Application Ref:	3/2021/0376	 Ribble Valley Borough Council www.ribblevalley.gov.uk	
Date Inspected:	12/5/2021		
Officer:	BT		
DELEGATED ITEM FILE REPORT:		Decision	Refusal

Development Description:	Proposed single storey extension to existing garage to create workshop area.
Site Address/Location:	Radley, Ribblesdale Avenue, Clitheroe. BB7 2HZ

2 PROPOSED NORTH WEST
1 : 100

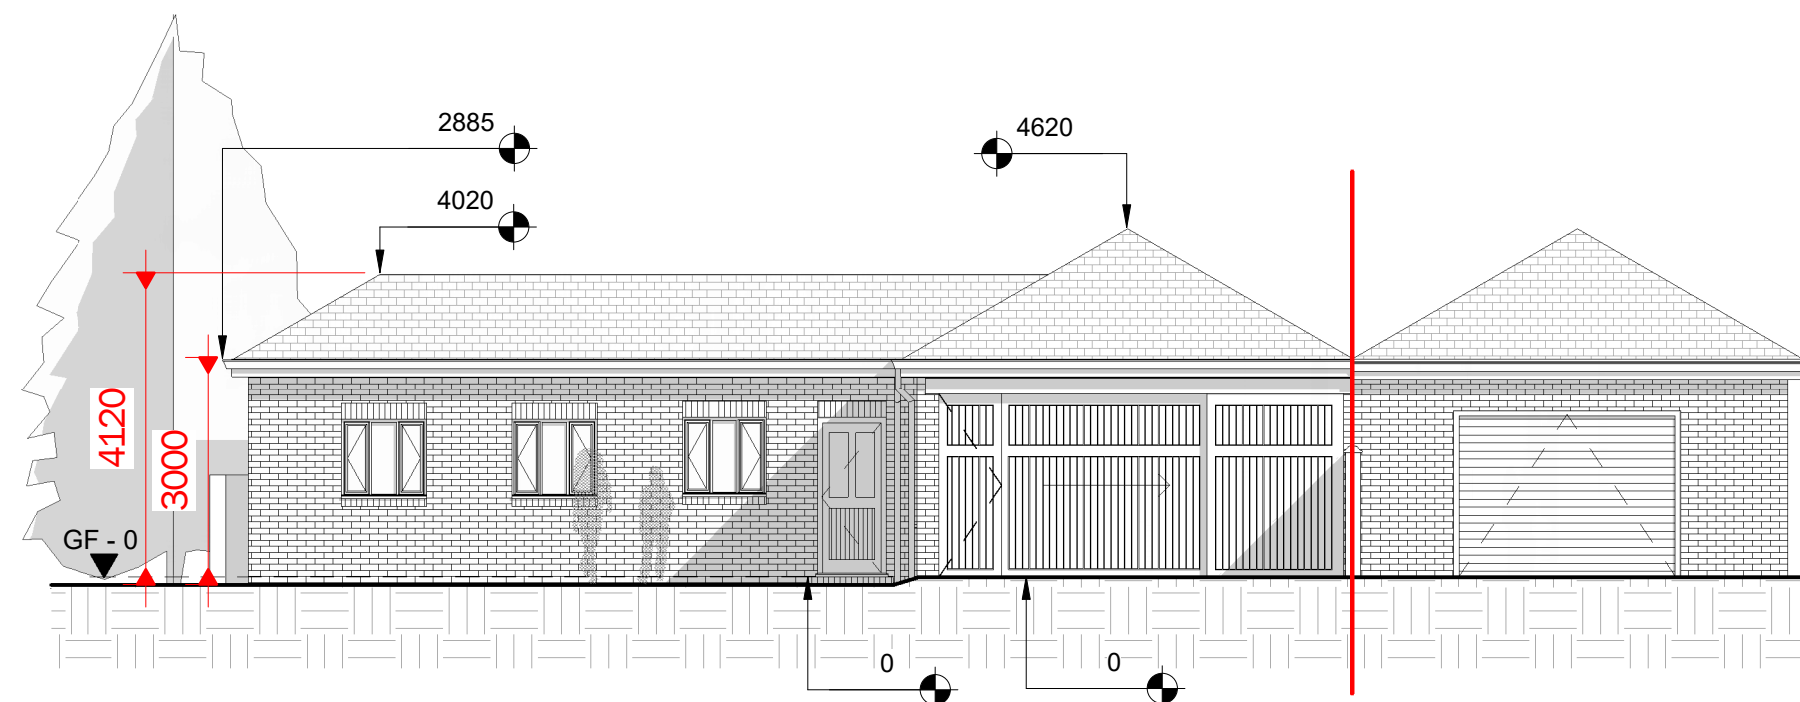
The proposed extension includes three windows on its North-western elevation. These windows will solely provide views into the property's rear garden and as such will not lead to any loss of privacy through overlooking.

4 PROPOSED NORTH EAST
1 : 100

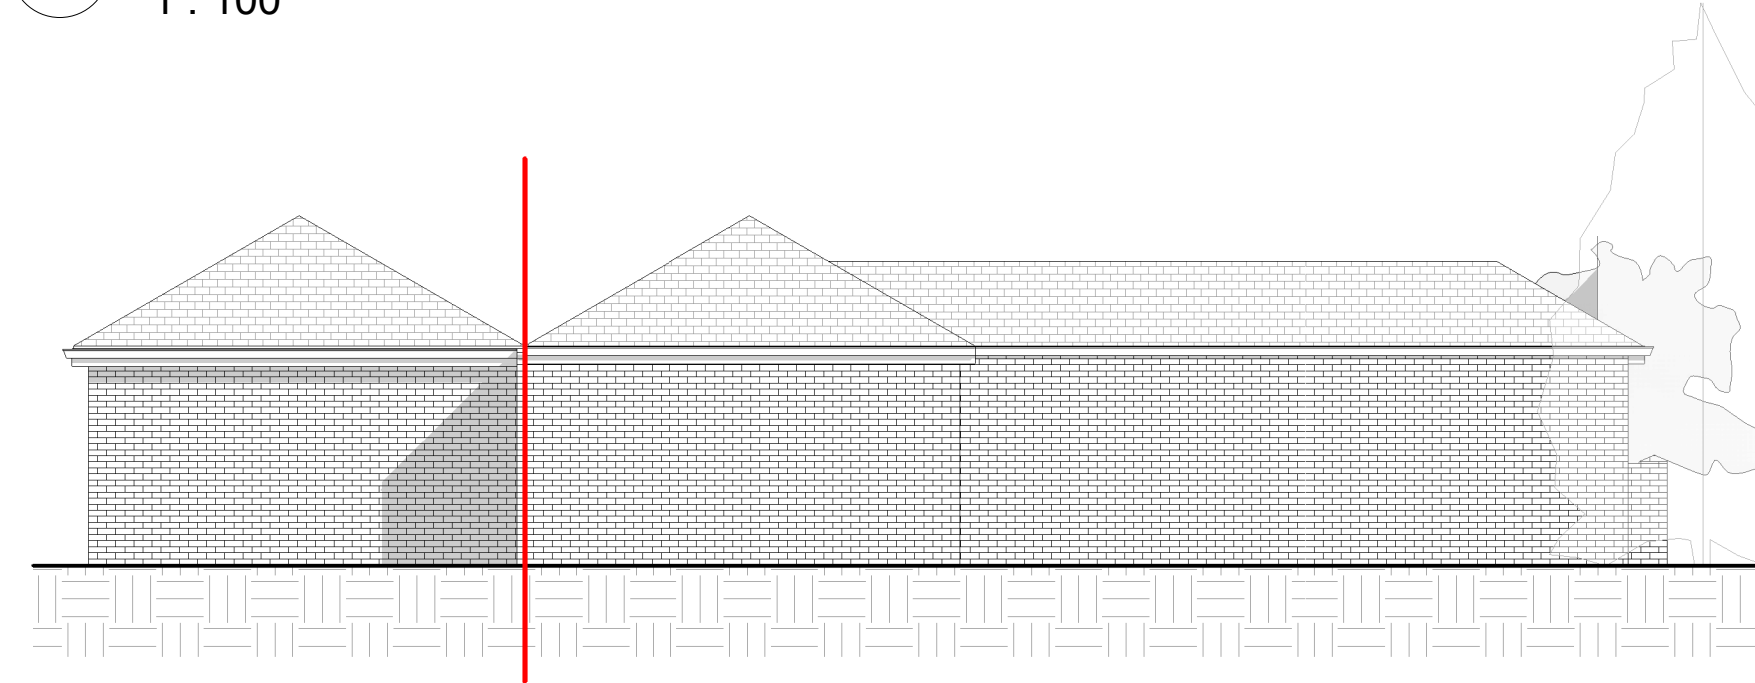
The North-eastern elevation of the proposed extension will adjoin the boundary wall with the neighbouring property of Northlands. The extension will project 2.3 metres above the boundary wall which will more than likely lead to some overshadowing within the South-eastern corner of the neighbouring garden however it is worth noting that this level of overshadowing is not considered to be severe enough to warrant refusal of the application in as much that the level of overshadowing would not affect the provision of natural light received through the rear elevation of Northlands.

6 PROPOSED SITE PLAN
1 : 200

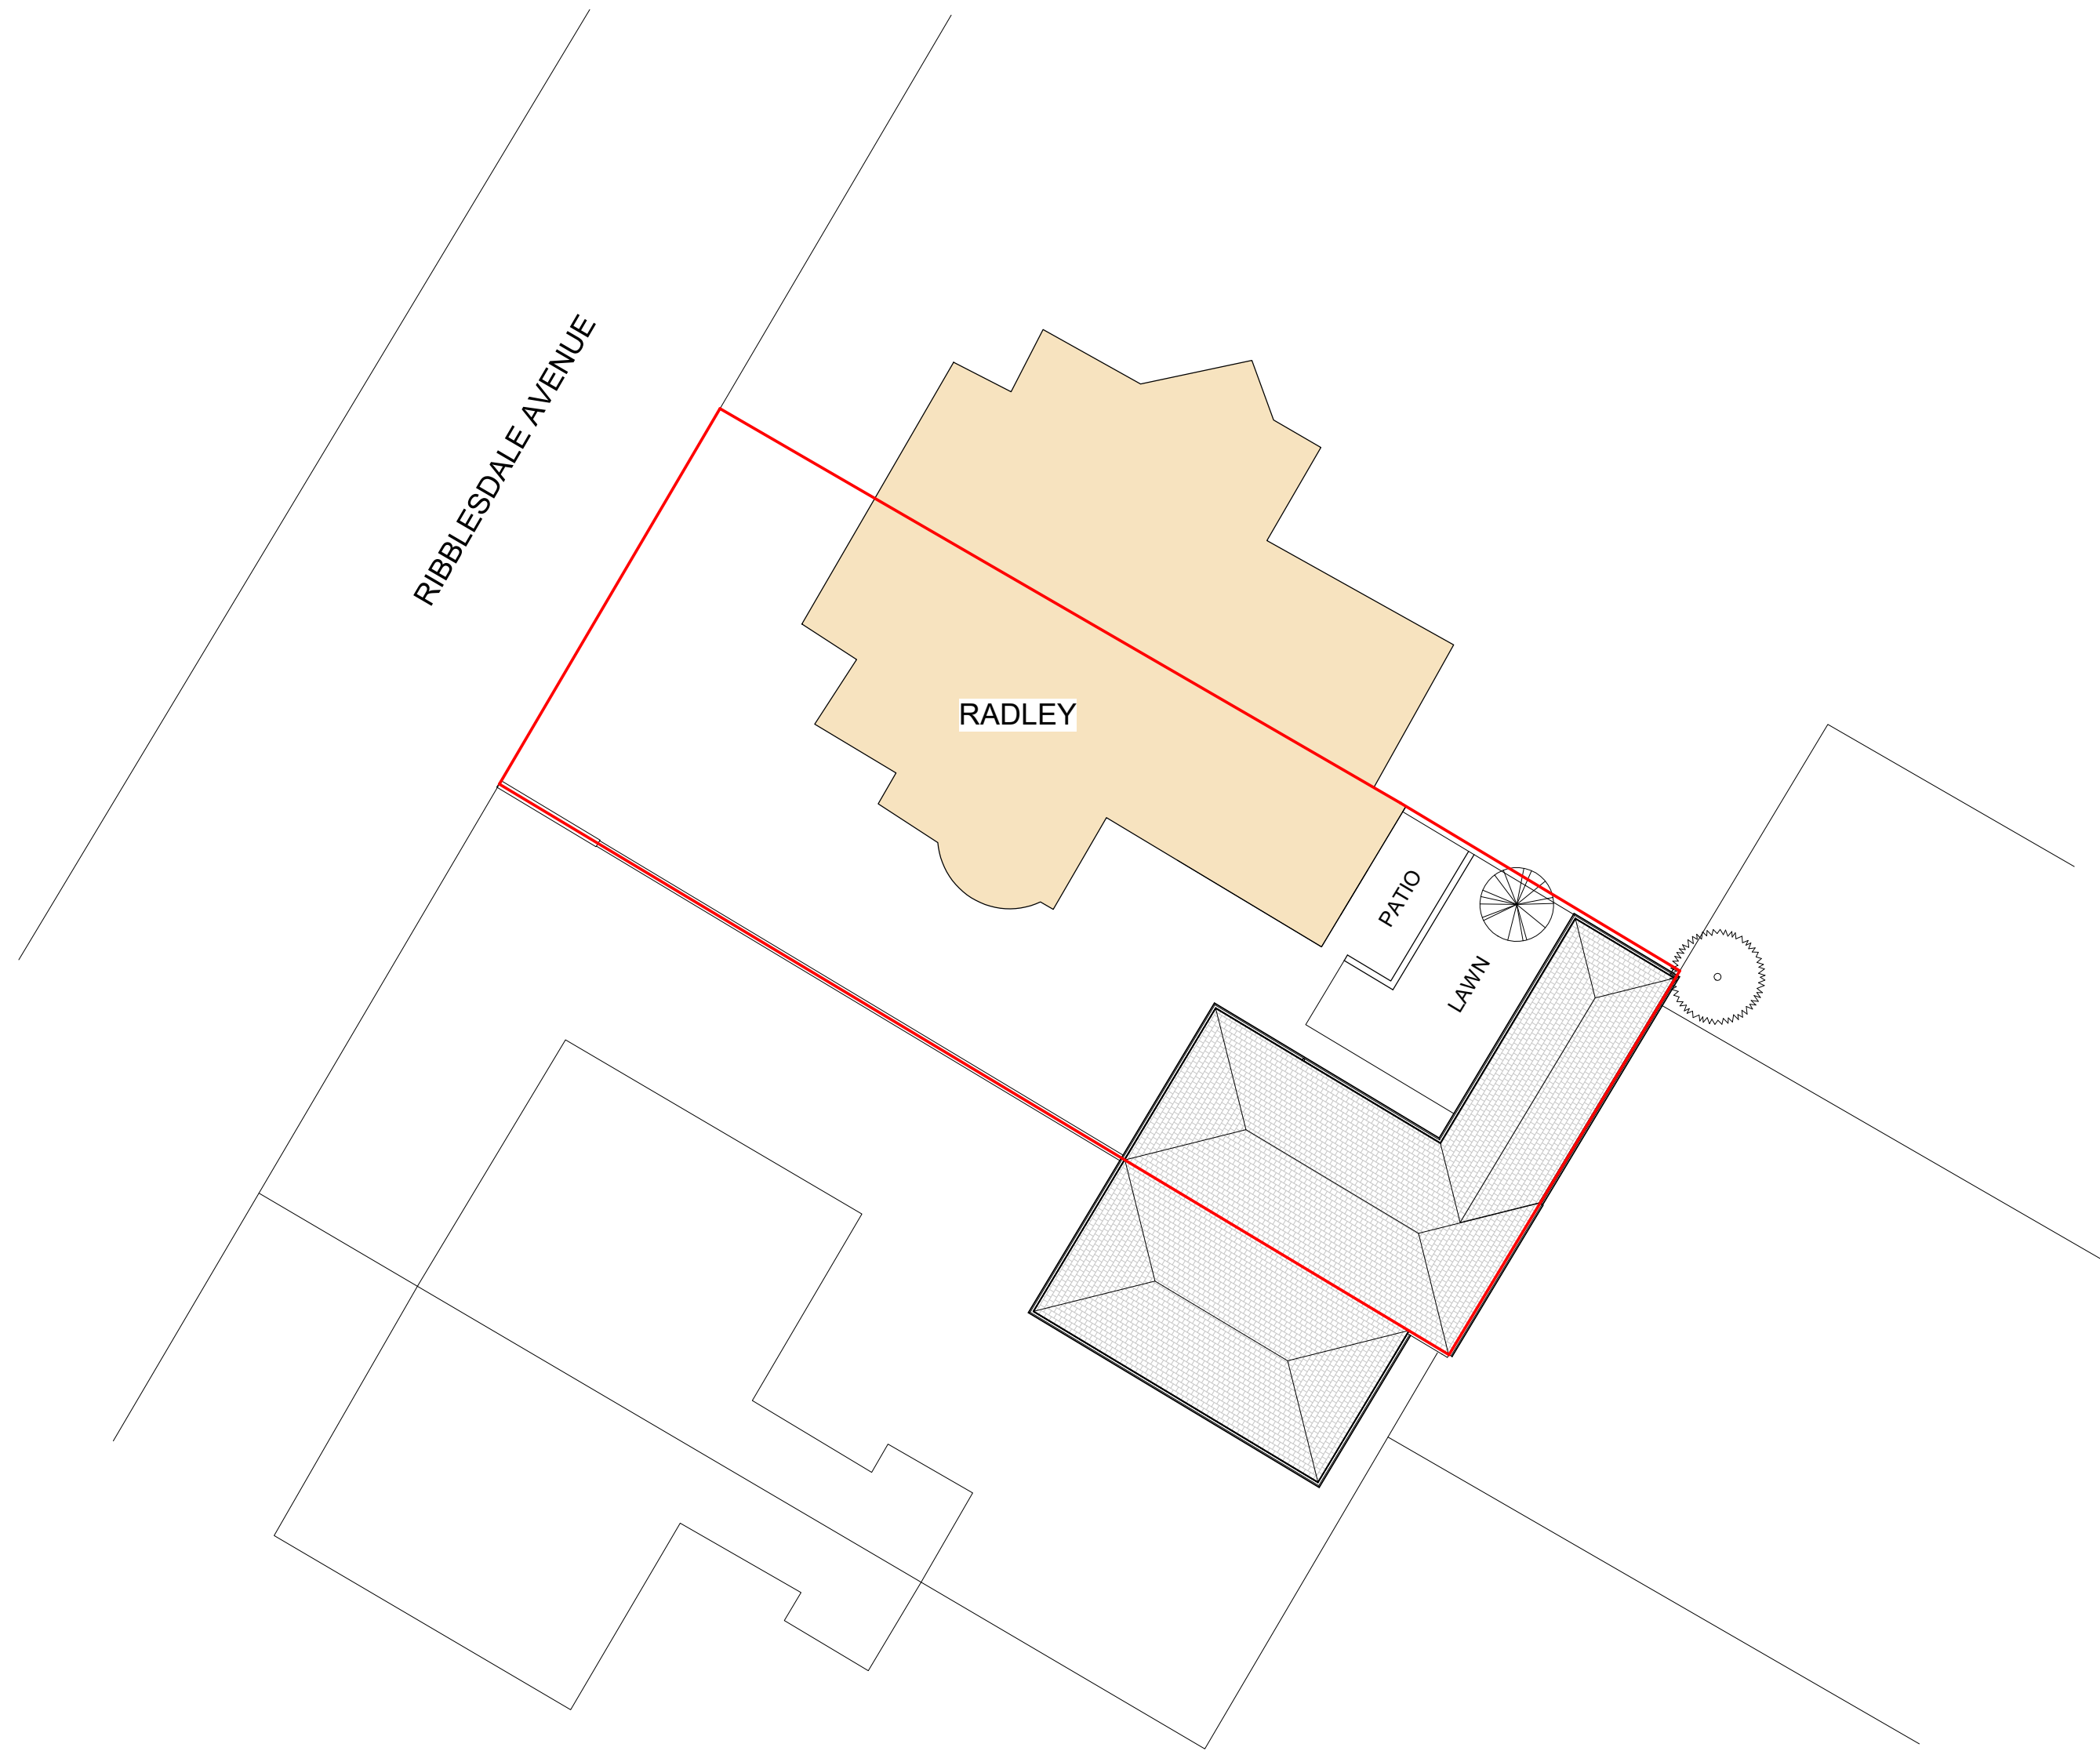
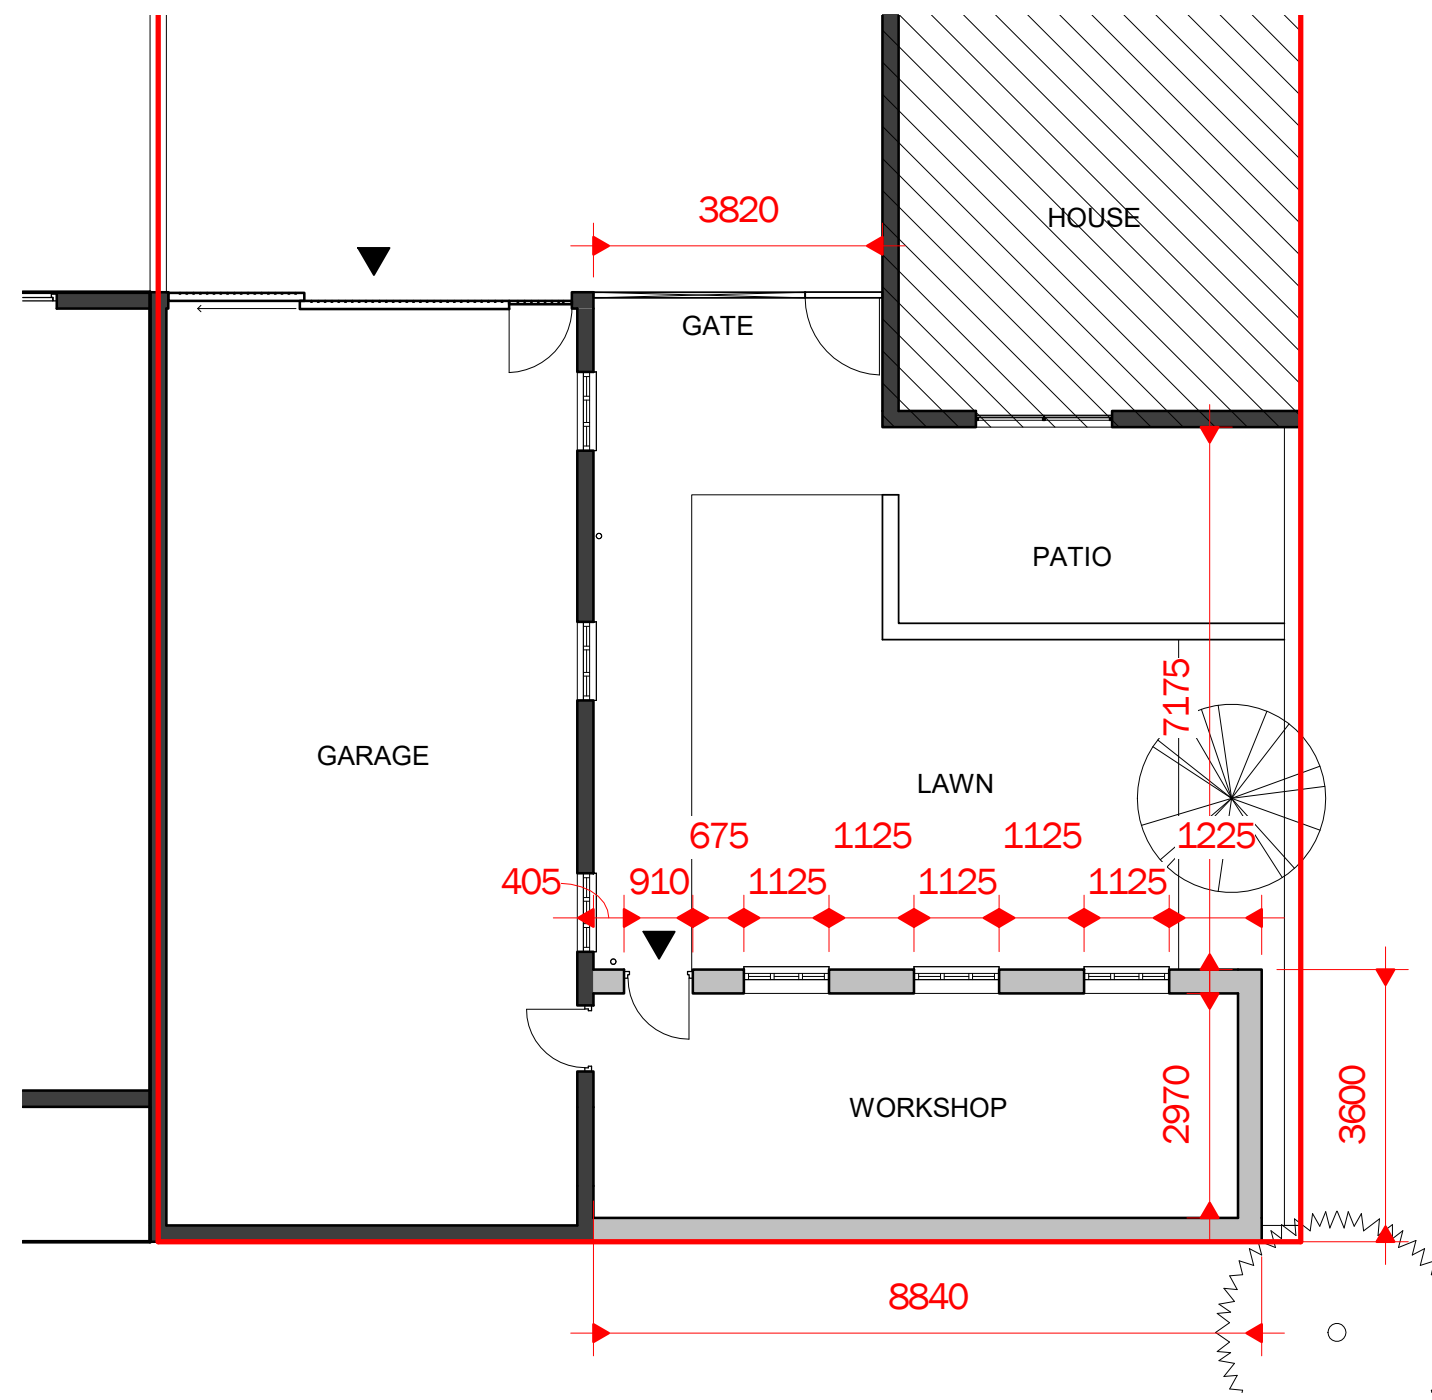
The extension will measure 8.8 x 3.6 metres with an eaves and roof height of 3 and 4.1 metres respectively which in turn would almost double the volume and footprint of the property's original garage. The extension would span the entire width of the property's rear garden wall and as such would be highly visible and overbearing to the residents of both No. 43 Hawthorn Place and Northlands.

Moreover, the overbearing presence of the extension would be further exacerbated by virtue of its eaves and ridge height both of which would project well above the height of the existing side and rear boundary walls shared with Northlands and No. 43 Hawthorn Place.

Furthermore, the extension would be sited in the South-eastern corner of the property's rear garden flush to the property's rear and side boundary walls which both serve as common boundaries with No. 43 Hawthorn Place and Northlands respectively. This proposed layout would result in the creation of an L shaped garage structure that would span both the side and rear elevations of the property's rear garden which in turn would be contrary to the existing spatial arrangement on the South-eastern side of Ribblesdale Avenue which is characterised by detached garages which run along the side boundary of their associated residential curtilages.

Policy DMG1 states that development must '*consider the density, layout and relationship between buildings, which is of major importance*' however in light of the above observations it is considered that the proposal categorically fails to give due consideration to the above policy through attempting to introduce a form of development that would be largely incongruous with and unsympathetic to the existing spatial arrangement between properties on Ribblesdale Avenue.
